Our ref: Marsden Park Data Centre (SSD-70889211)

Subject: Additional Matters for Submissions Report (SSD-70889211)

The Department's comments on the Environmental Impact Statement (EIS)

DRAWING: **SITE PLAN**

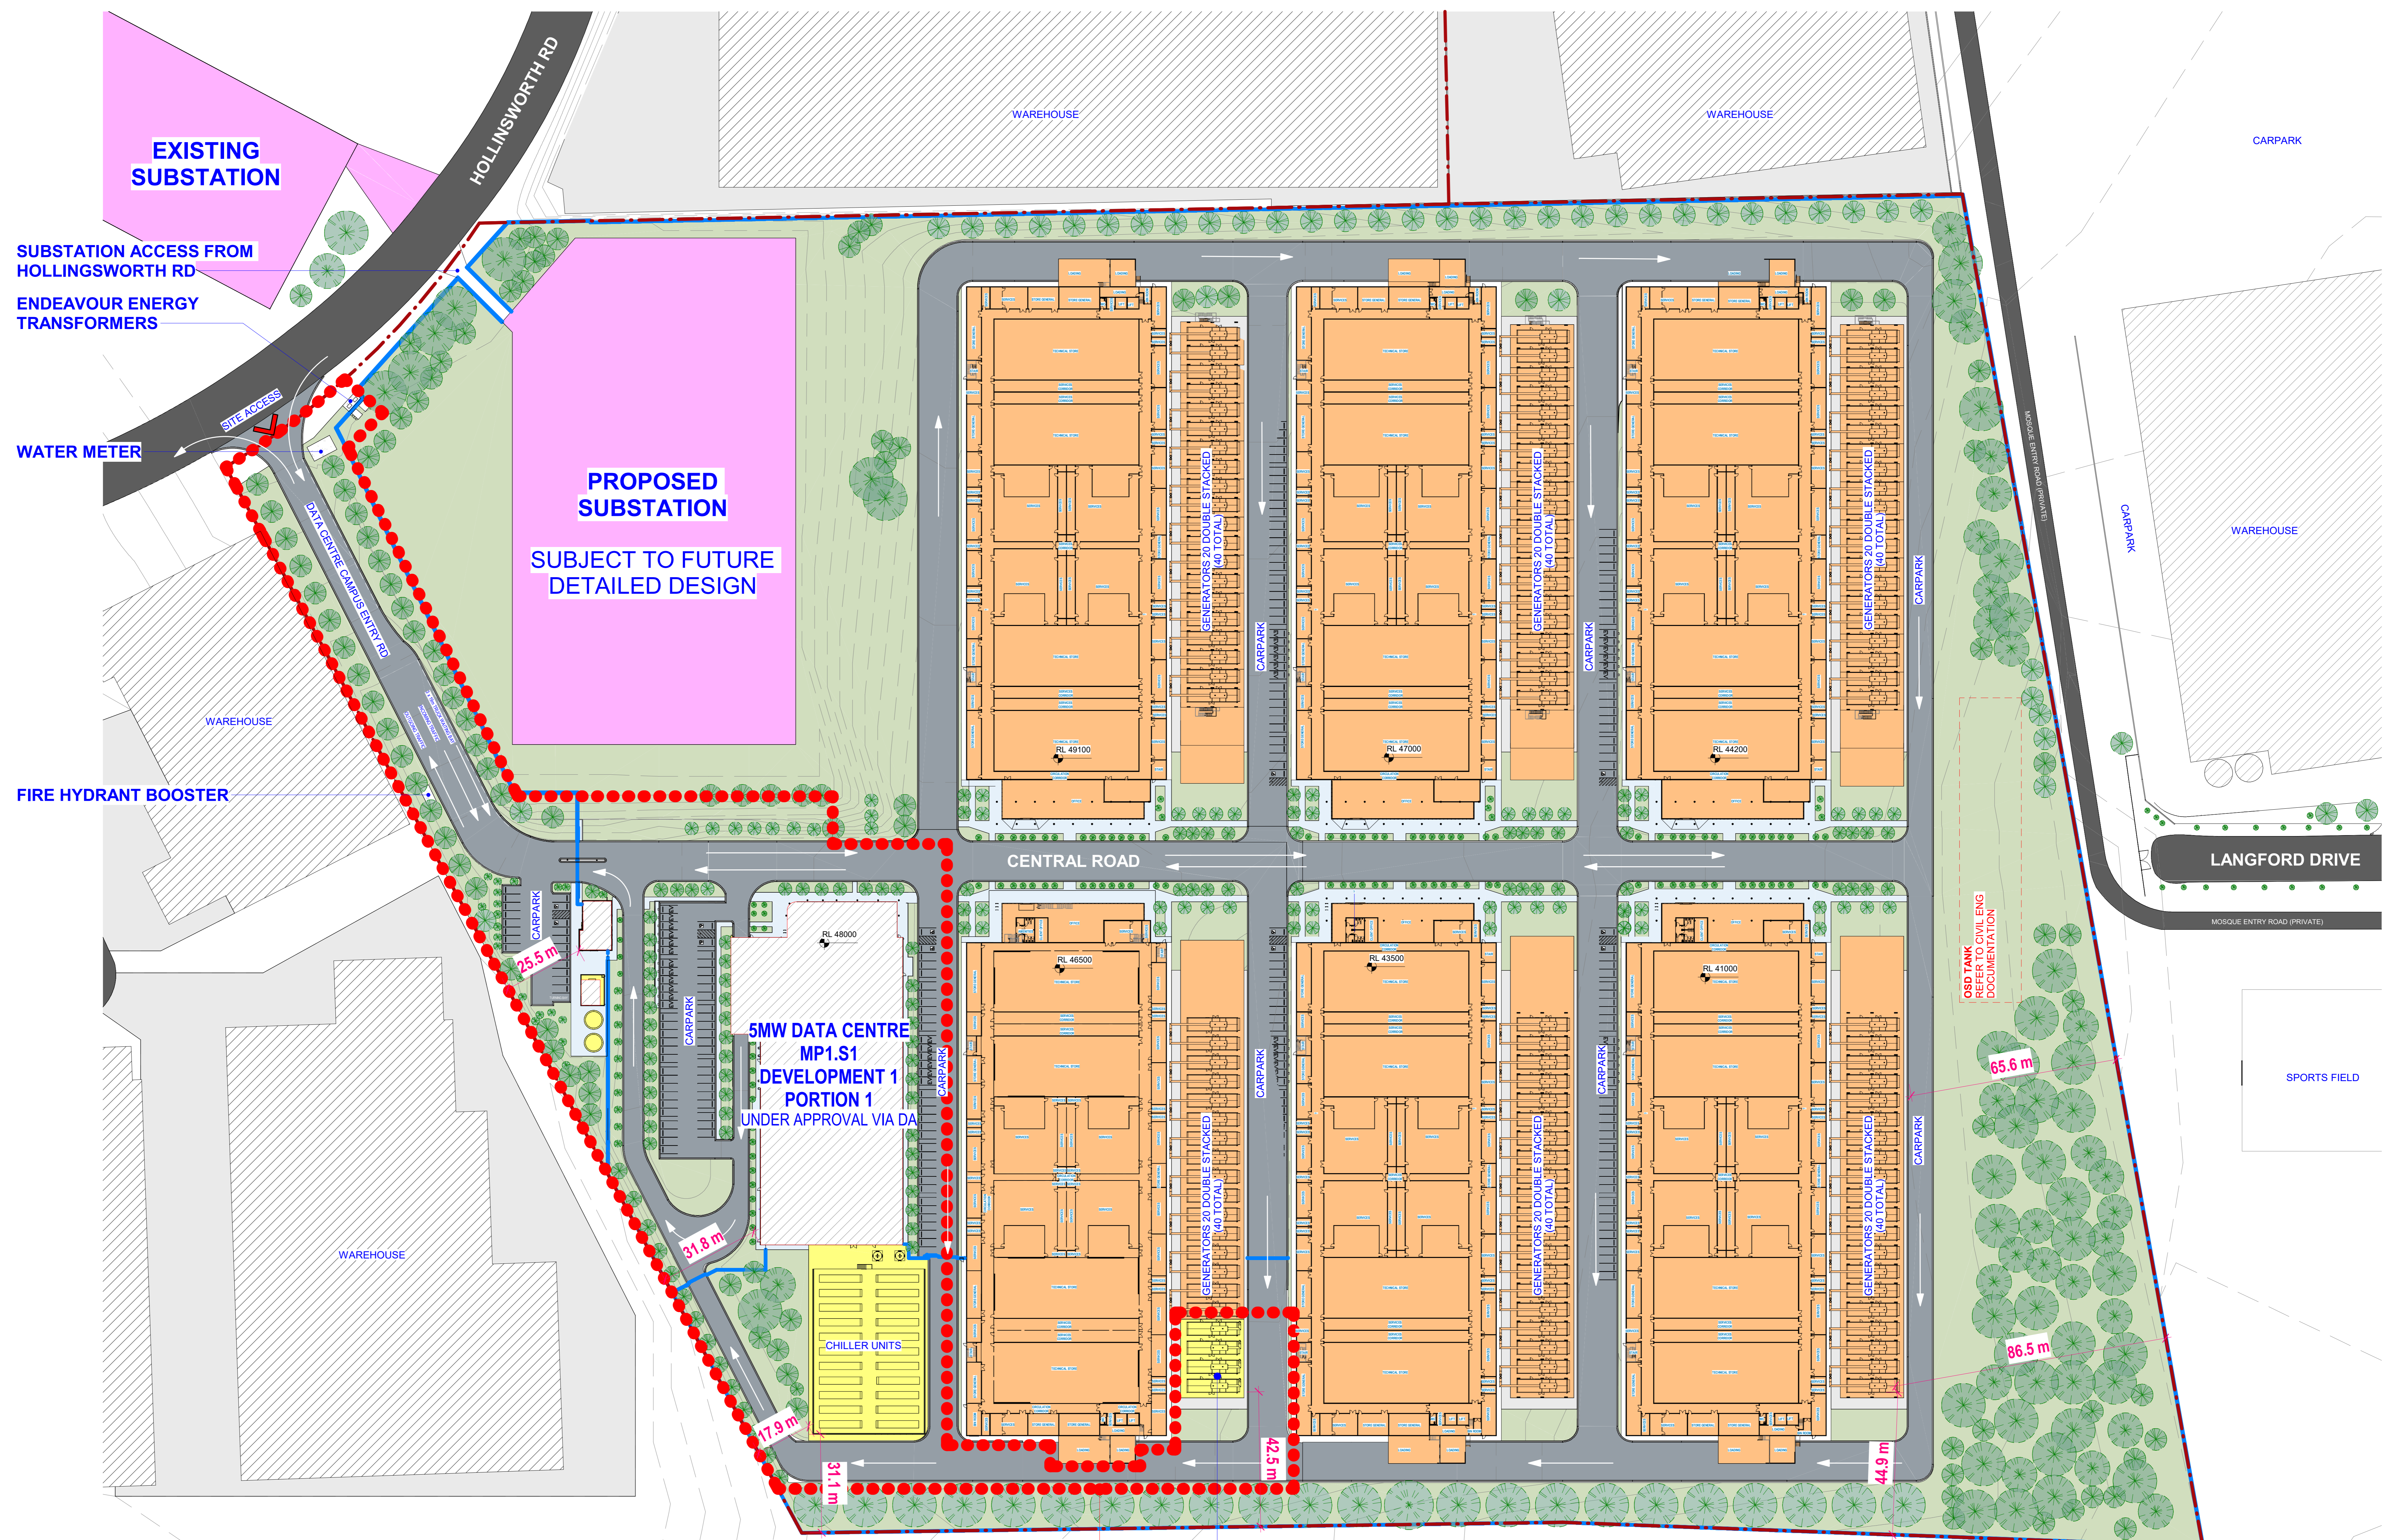
30. The Department notes the skybridges located adjacent to the southern boundary of the site may result in privacy concerns for residences to the south.

In this regard, please provide further information to confirm what privacy impacts (if any) the skybridges will have on residences in this area and, if necessary, identify suitable management and mitigation measures (i.e. the use of frosted/opaque glass).

32. The Department has concerns regarding the extent of the landscaping buffer provided adjacent to the site's southern boundary, particularly given the encroachment of each data centre building's Asset Protection Zone (APZ) upon the landscaping and the associated restrictions around tree planting and ground cover species.

The Department recommends the landscaping scheme be revised and the southern landscaped buffer area increased (where possible) to prevent the development's APZs from impacting on these areas, and to subsequently provide further opportunities to soften and alleviate the significant size and scale of the proposed data centre buildings when viewed from residences to the south of the site. These changes may also help to negate the need for a Biodiversity Development Assessment Report (BDAR) to be prepared for the development (see relevant section below).

**TYPICAL BUILDING (DEVELOPMENT 2-6, DEVELOPMENT 1 SIMILAR)**  
**ROOF PLAN**

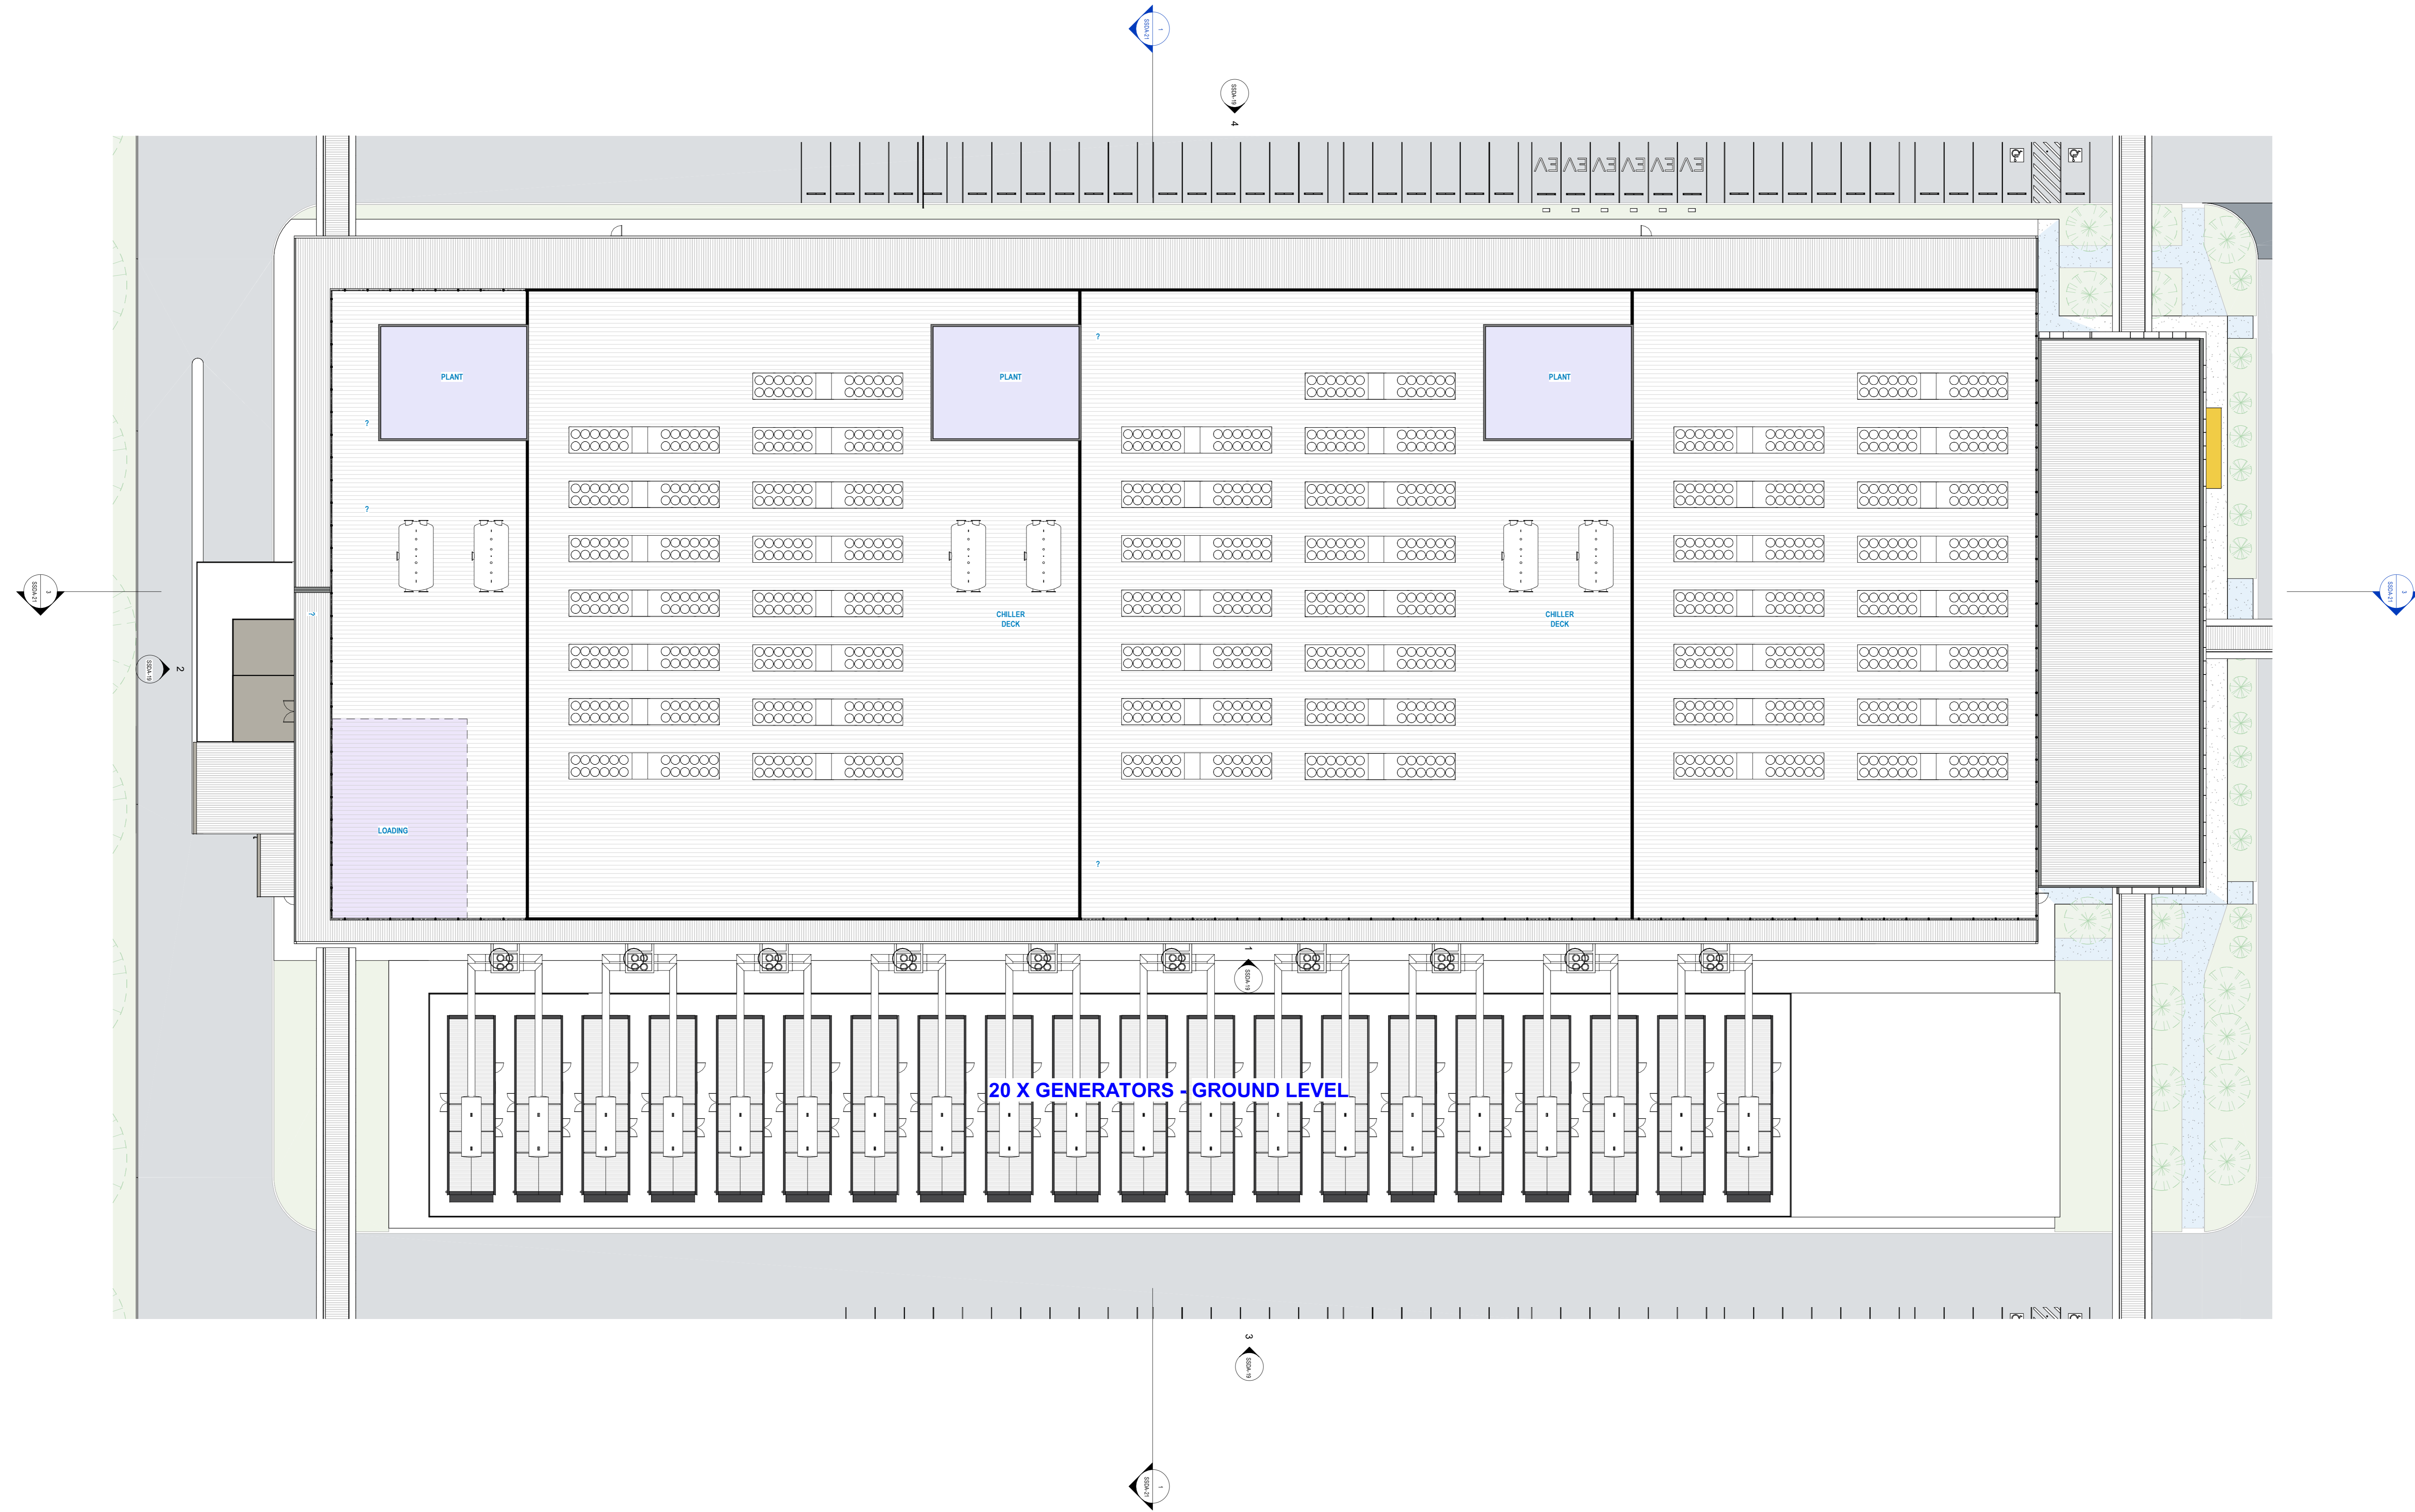
28. Given the proposed acoustic barrier treatments differ across each building, please provide detailed architectural plans for each of the six data centre buildings proposed under the subject SSD application.
29. The Department has concerns regarding the design of the development’s southern and eastern façades, particularly when viewed from residences to the south of the site.
